ATTACHMENT 1

Office of Environment and Heritage (OEH) comment on the proposed Energy from Waste Facility (SSD 6236) at lots 1, 2, 3 and 4 DP 1145808, Honeycomb Drive, Eastern Creek

Figure 19: EFW South Artefacts over Proposed Impact Area

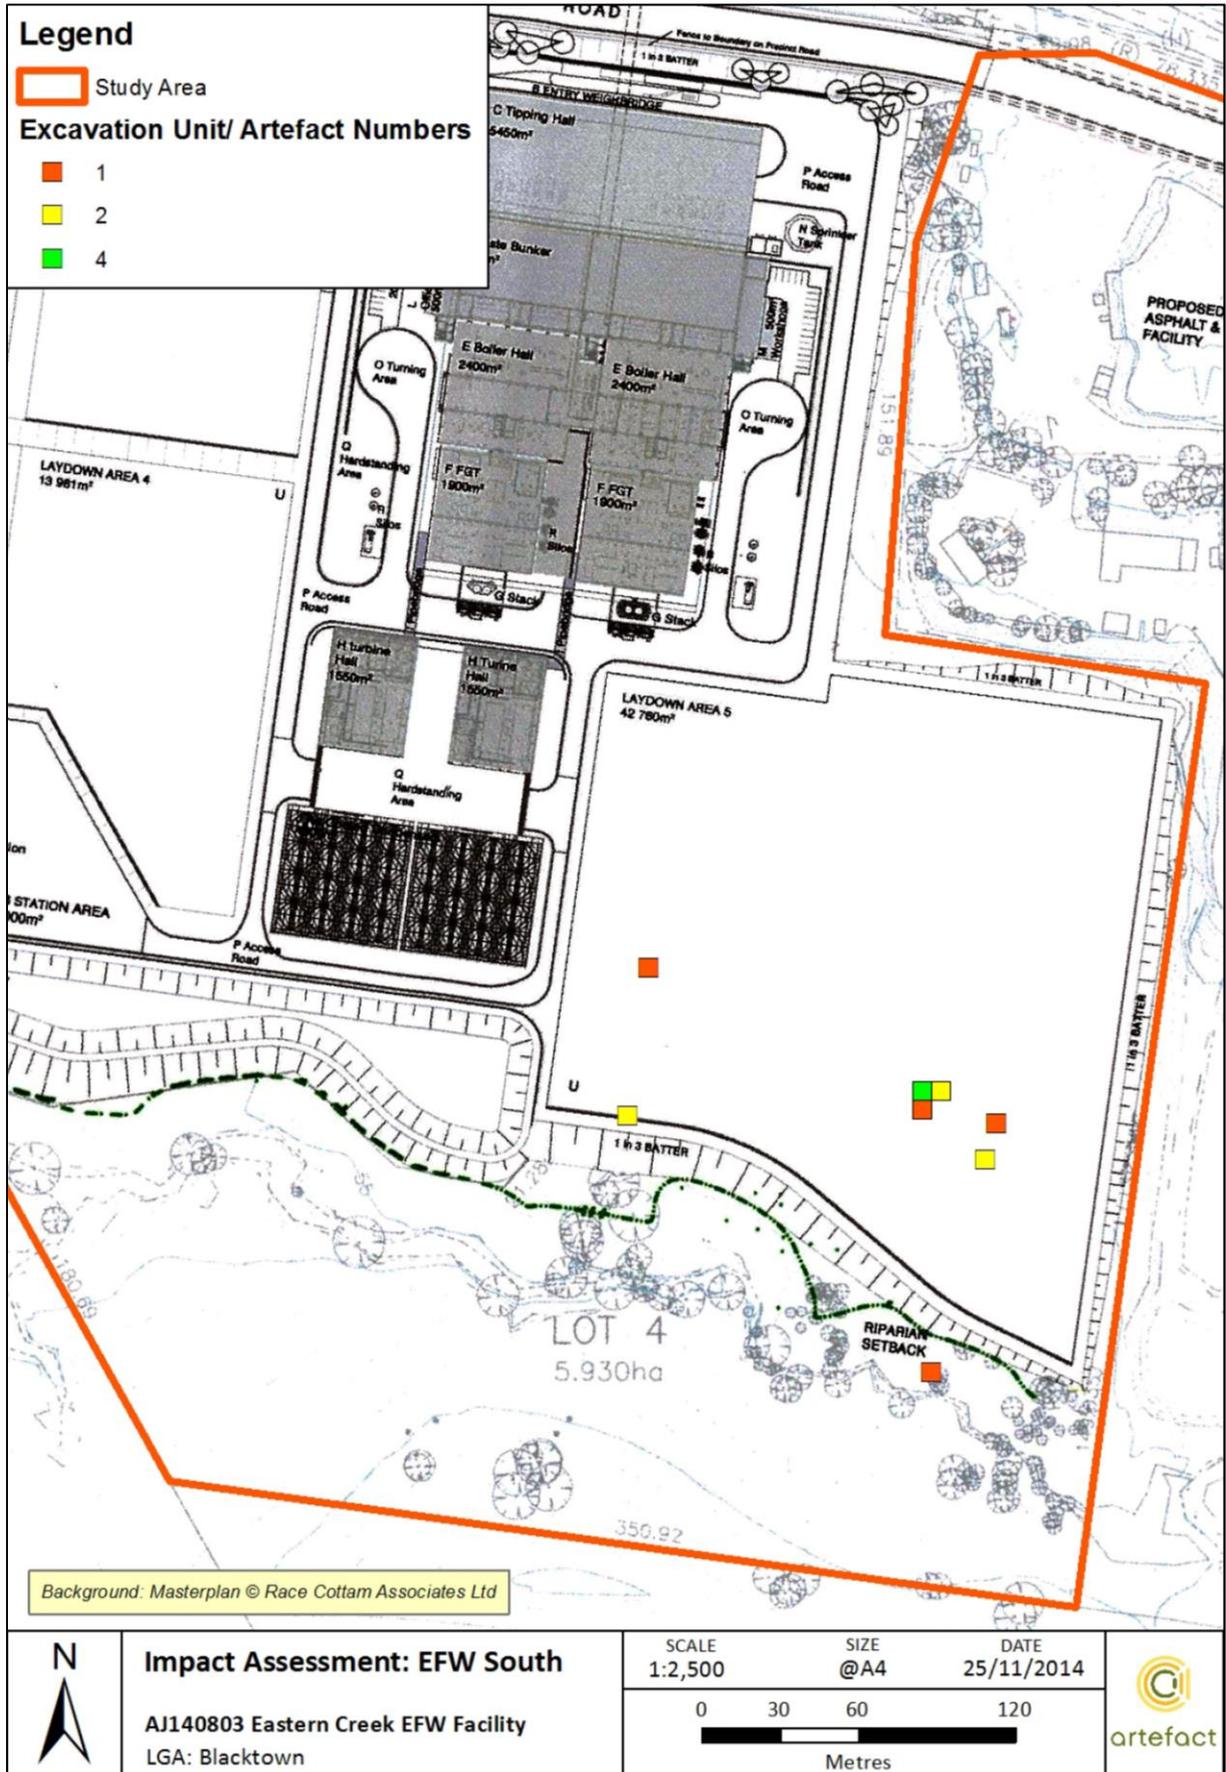
OEH notes that the proposal will cause harm to one site known as EFW South, which has been investigated through test excavation and this has confirmed the nature, extent and significance of the likely archaeological deposit. OEH is satisfied that this assessment has been adequate to appropriately investigate and document the likely archaeological resource at this location where harm is proposed by this development. It is further noted by OEH that the EIS states that land zoned as "E2 conservation" within lot 10 will be retained undeveloped in the future. This area retains an AHIMS site identified by GML Heritage as "Archbold Road 1" and has been assessed as containing high Aboriginal archaeological sensitivity, as well as ecological value. The preservation and conservation of this site within this area of environmental protection is supported by OEH without further test excavation to confirm its archaeological values.
